28 February 2019

PROPOSED REDEVELOPMENT OF
WENTWORTHVILLE PUBLIC SCHOOL
70 - 100 FULLAGAR ROAD
WENTWORTHVILLE

This Practice has been engaged by Fulton Trotter Architects on behalf of the Department of Education NSW (DoE) to address the items raised within the abovementioned correspondences, as it relates to traffic and parking. It is noted that these comments have been addressed in the revised Traffic and Transport Impact Assessment Report (TTIA), which is submitted as a separate document. The following provides a summary of the sections of the amended TTIA in direct response to these comments.

DRAWING
END OF TRIP FACILITIES SITE PLAN

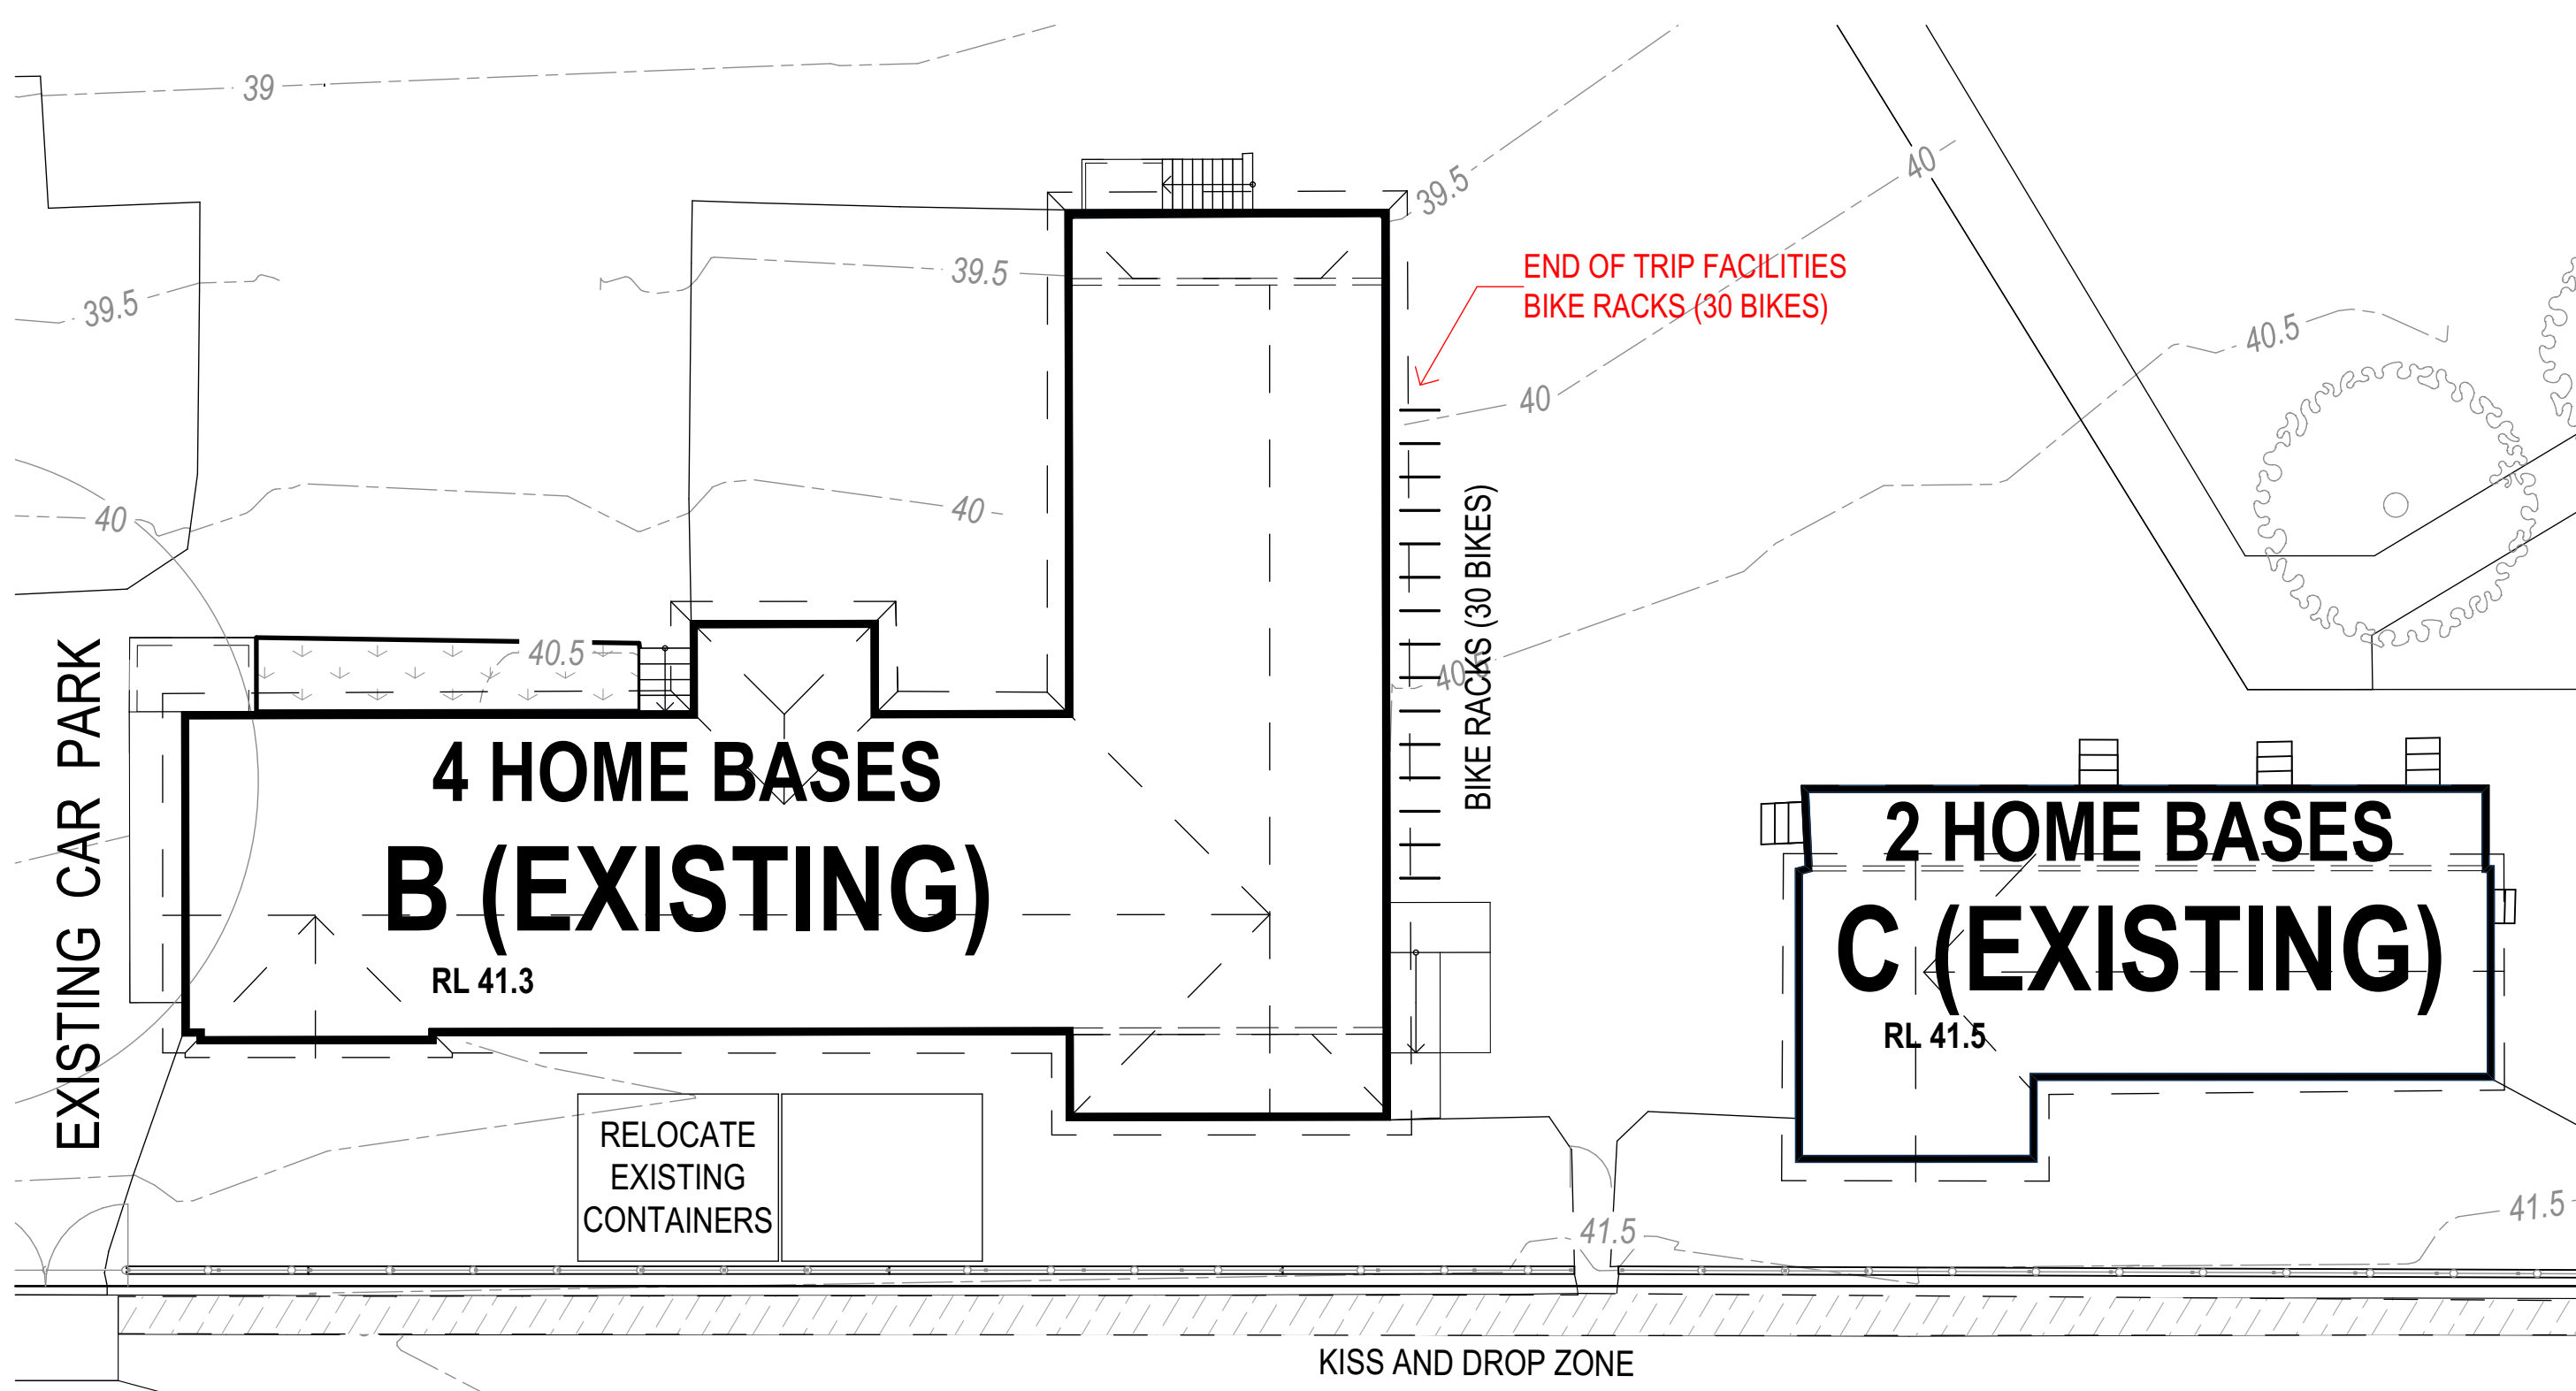
TfNSW comments: It is unclear from the traffic assessment whether there are appropriate existing end-of-trip facilities to support staff cycling trips to/from the school. If there is currently no provision for end-of-trip facilities within the school, one should be provided as part of this redevelopment proposal.

The DoPandE states: Clarification should be provided whether end-of-trip facilities would be provided on-site and that these facilities would be adequate having regard to the proposed staff and student numbers.

TfNSW comments: It is unclear from the traffic assessment whether there are appropriate existing end-of-trip facilities to support staff cycling trips to/from the school. If there is currently no provision for end-of-trip facilities within the school, one should be provided as part of this redevelopment proposal.

Based on information provided by the Fulton Trotter Architects, the following end-of trip facilities are proposed to be provided as part of the subject application:

- Bicycle racks are to be provided for use by staff adjacent to Building B;
- Showering facilities for staff are to be provided within Building E; and
- Storage lockers for staff are to be provided within Building E.
